## DEPARTMENT OF PUBLIC WORKS

### MEMORANDUM

SUBJECT: Take Five Plat LP-08-00032

TAKE FIVE PLAT			
PORTION OF THE E 1/2 OF THE E 1/2 OF SECTION 21 AND A PORTION OF THE W 1/2 OF THE W 1/2 OF SECTION 22, TOWNSHIP 15 NORTH, RANGE 19 EAST, W.M. KITTITAS COUNTY, WASHINGTON			
DWN BY	SFT	DATE	JOB NO.
CHKD BY	SCALE		
D. NELSON	1"=200'	11/2008	08124
			SHEET
			1 OF 2

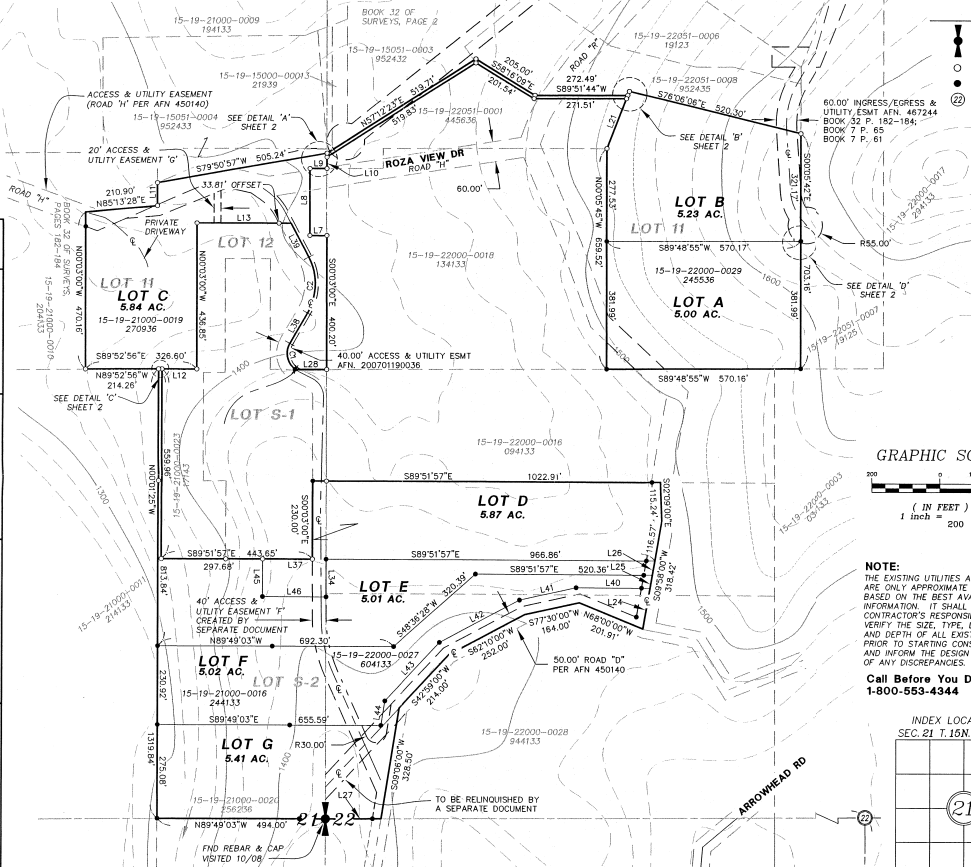
Documentation was received for Road "D" and Road "H". However, a 60' easement is also required for the easement that serves Lots D, E, F & G. Kittitas County Department of Public Works will grant conditional approval after this information is received. Please contact me if you have any questions.

- a. Access easements shall be a minimum of 60’ wide. The roadway shall have a minimum width of 20’, with 1’ shoulders, for a total width of 22’.
